ARUN DISTRICT COUNCIL TECHNICAL SUPPORT
23 JUN 2015
ACTION...

Ref. Planning Reference F/7/15/OUT

Our main objection to this application is the realignment of Burndell Road.

Proposed access and highway improvements plan (Stiwell Partnership)

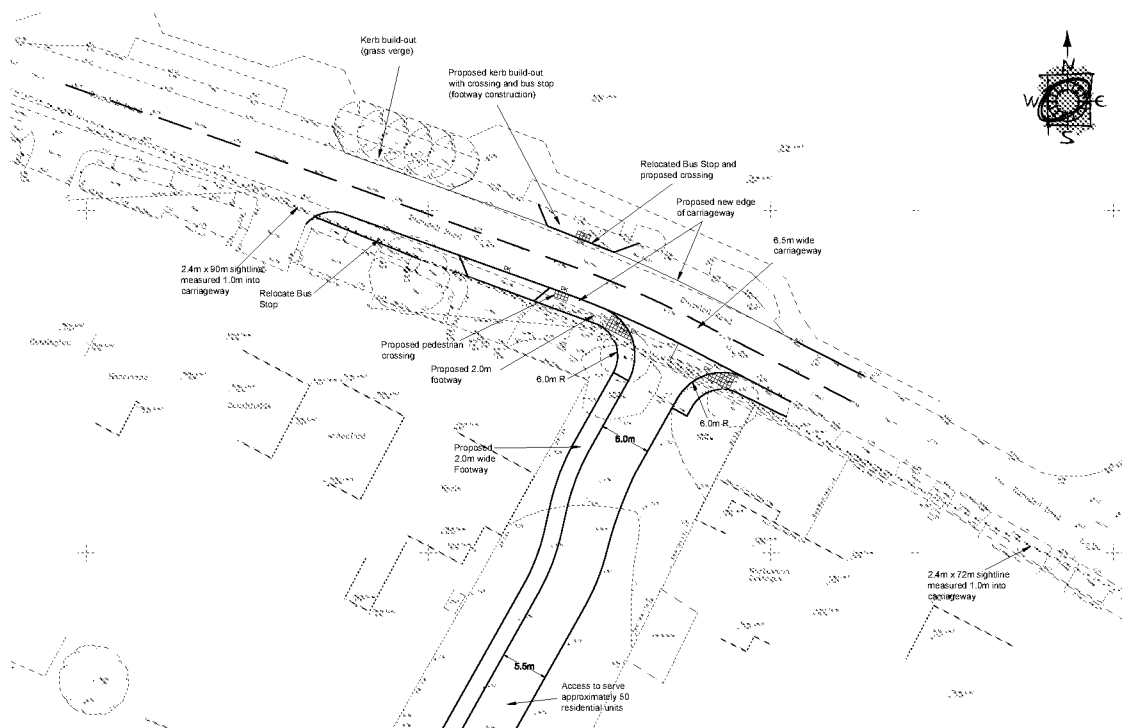
1. Road Safety with vehicles exiting on to the apex of a blind bend.
2. The loss of the layby is totally unacceptable as this provides safe entering/ exiting from out properties.
3. The layby was part of the planning requirement in 1963 to allow resident parking.
4. We have been advised that this area is not owned by the West Sussex County Council although user rights have been established.
